**KIRKLEES METROPOLITAN COUNCIL  
INVESTMENT & REGENERATION SERVICE**

**DELEGATED DECISION TO DETERMINE PLANNING APPLICATIONS**

Reference No:	<b>2026/62/90809/W</b>
Site Address:	8, Black Rock Drive, Linthwaite, Huddersfield, HD7 5ZA
Description:	Conversion of existing garage to form living space (within a Conservation Area)
Recommending Officer:	Joshua Merriman

## **Officer Report – 2026/90809**

# **Front Elevations (Final Dimensioned Issue)**

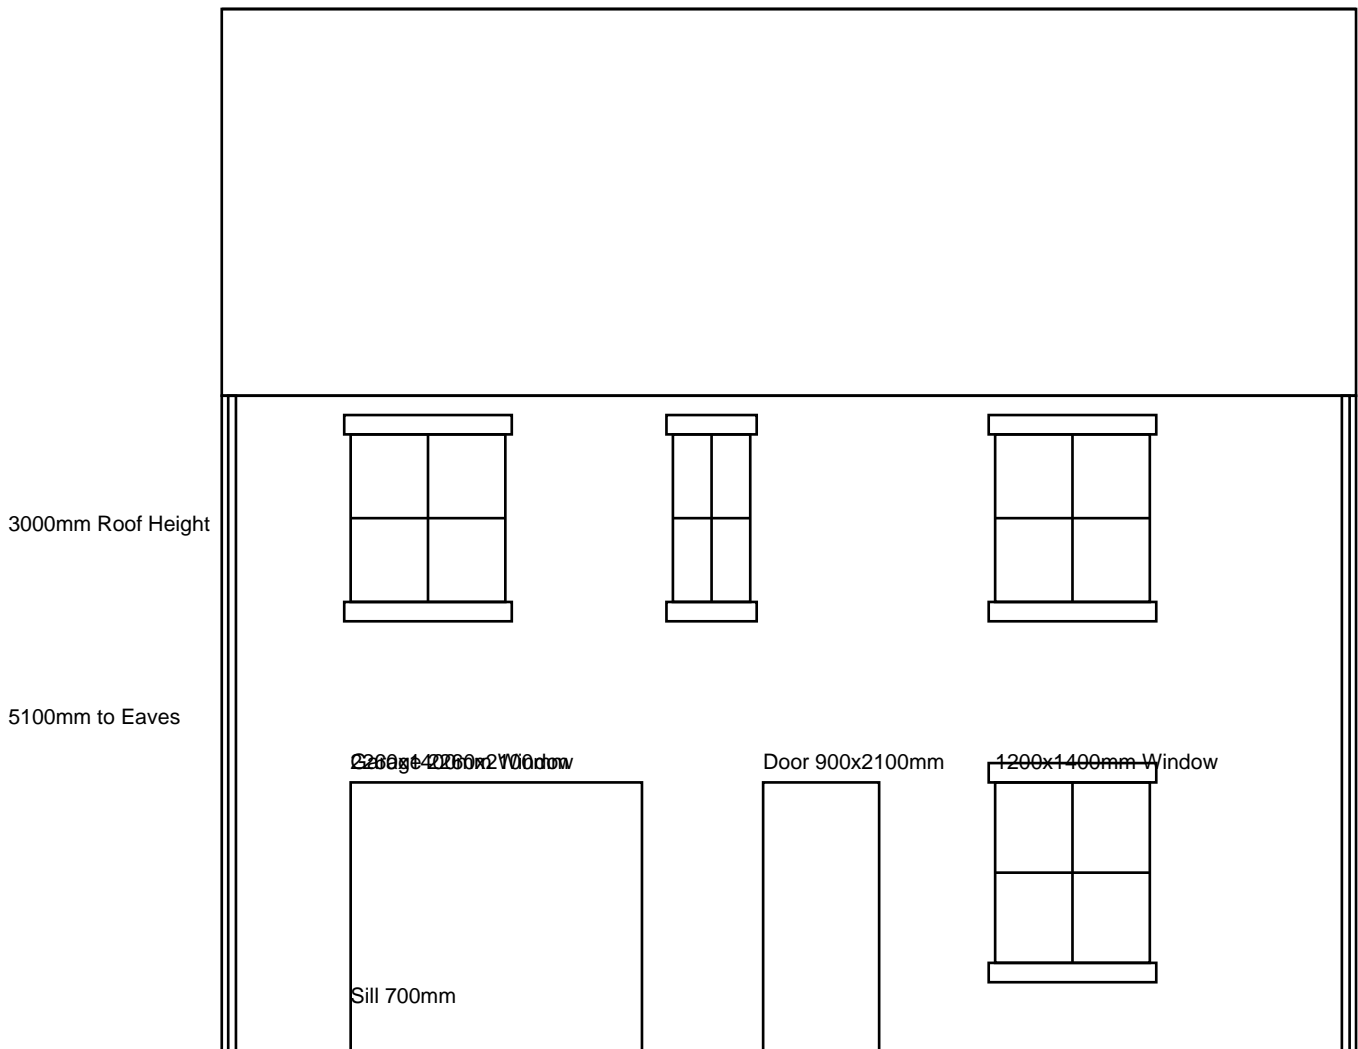
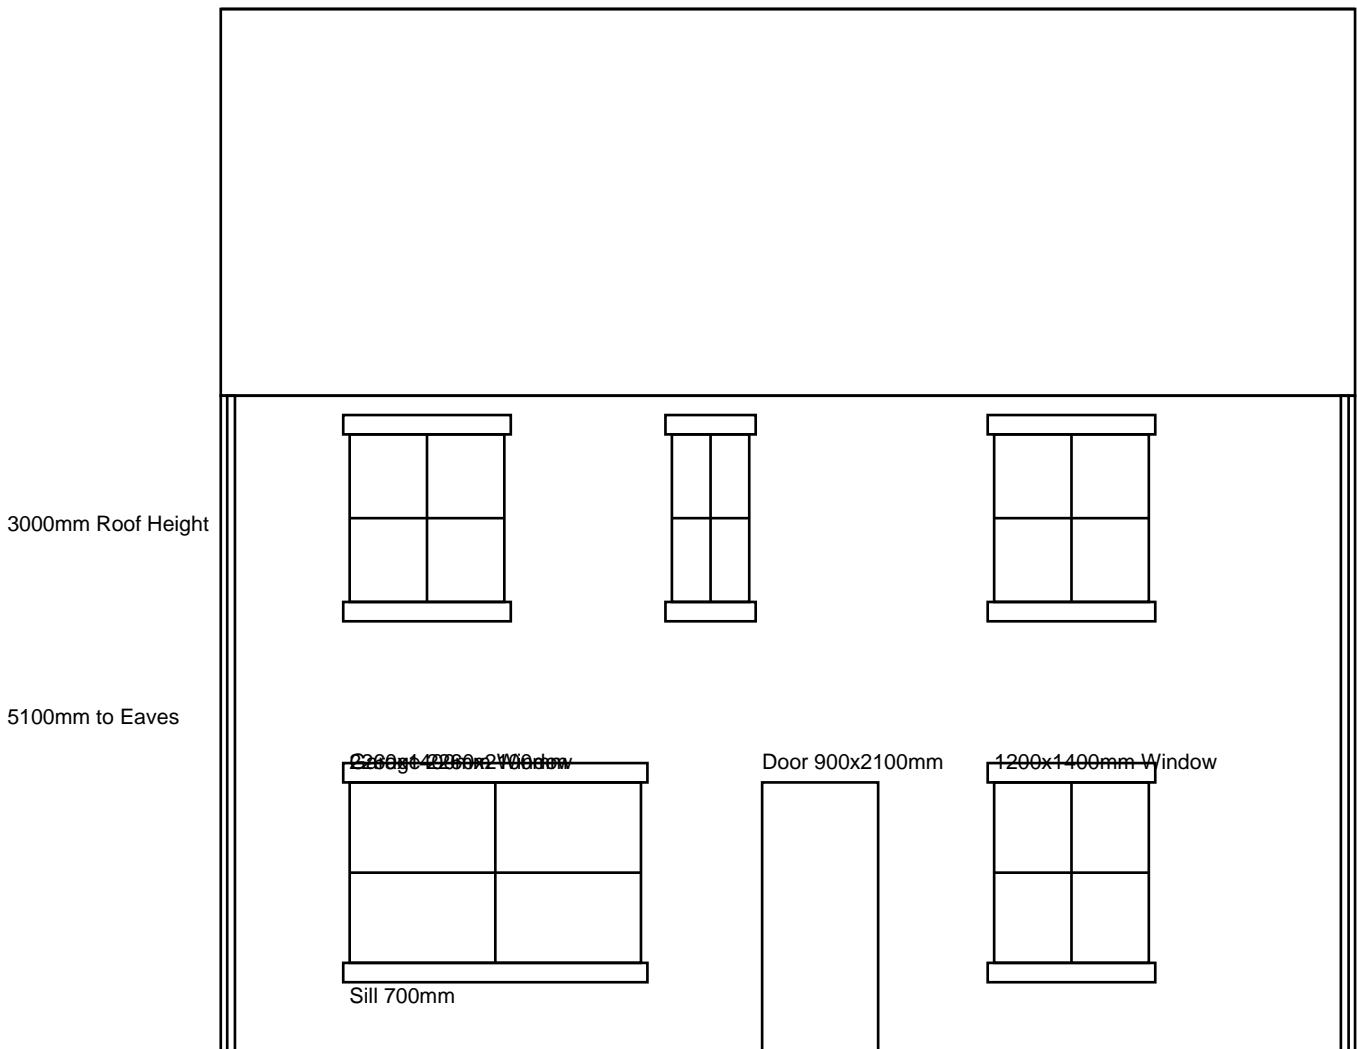
The proposed alterations will not increase the footprint of the dwelling and the changes incorporate cream uPVC windows and marshall buff marshalite

stone and sills, all to match the existing building. The works are designed to match the host and considered acceptable within the street scene. They will not detract from the character of the host property or visual amenity of the area.

Furthermore, as the closest neighbouring property to the East is 18m away, the proposed openings will project no further forward than those existing in the front elevation of the application property, and the closest neighbouring windows are at first floor level rather than ground floor to match those proposed in this application, it is considered that there will be no extra impact upon neighbouring occupants regarding privacy and overlooking.
